Your Ref: OWPC24612
Our Ref: LU/282/19/PL
Please ask for:
Mr Z Denton

Replacement of 6 No. windows in communal hallway from single glazed in wood frames to double glazed PVCu.

The Swallows St Catherines Road Littlehampton

FLATS 1 - 6 EXISTING WINDOWS

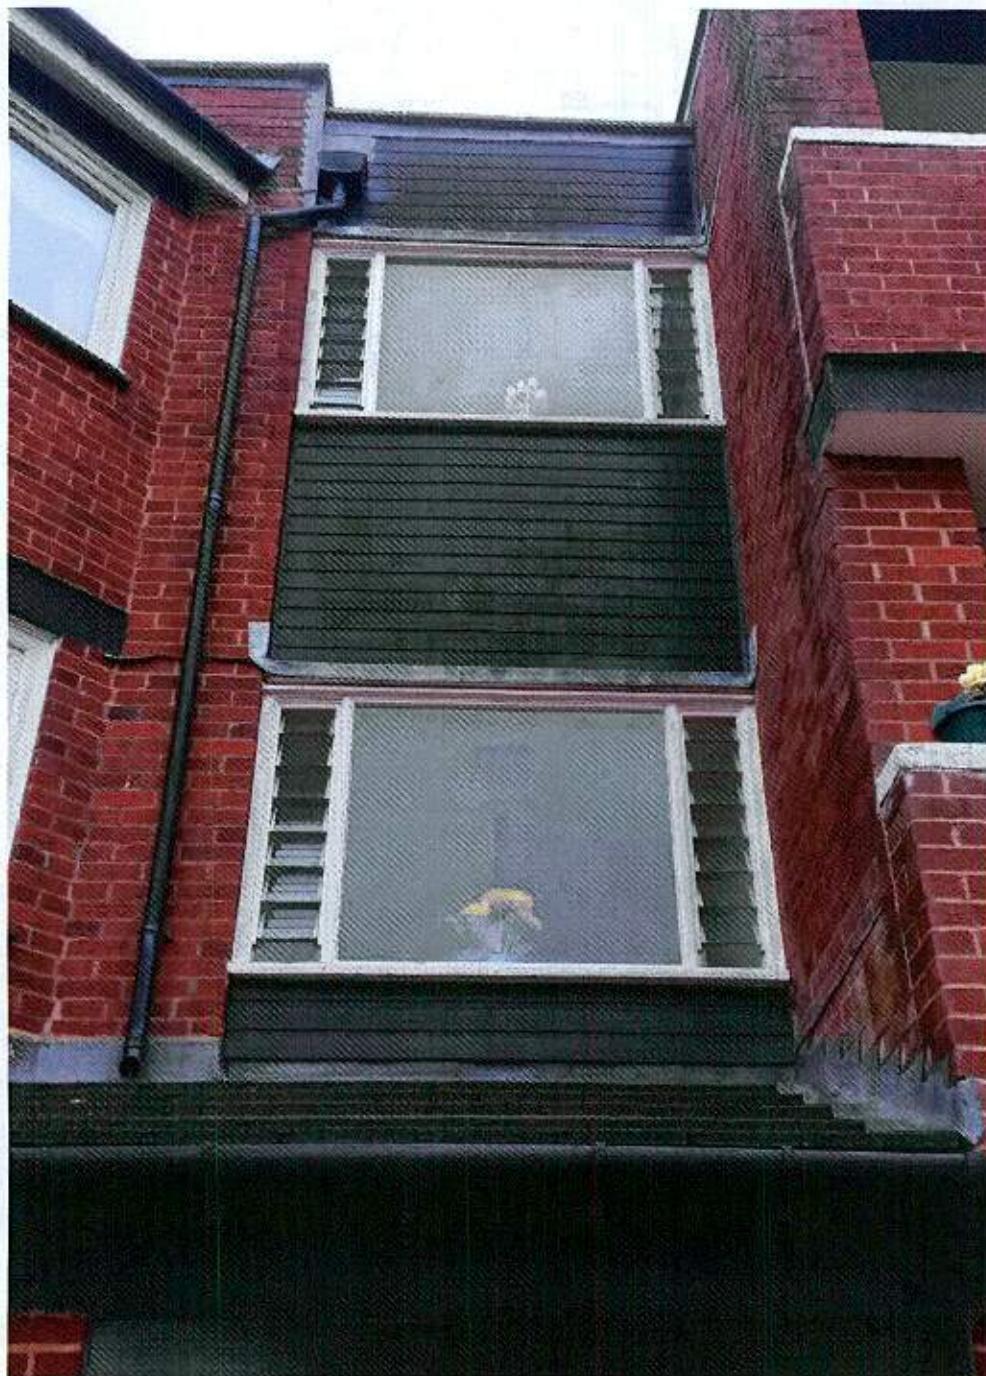
The Town Council's Planning and Transportation Committee considered this matter at its meeting held on Monday 14th October 2019 and objected to the application. Whilst the Committee was not opposed to the principle of replacing the windows, the visual impact of the design of the replacement was not in keeping with the existing.
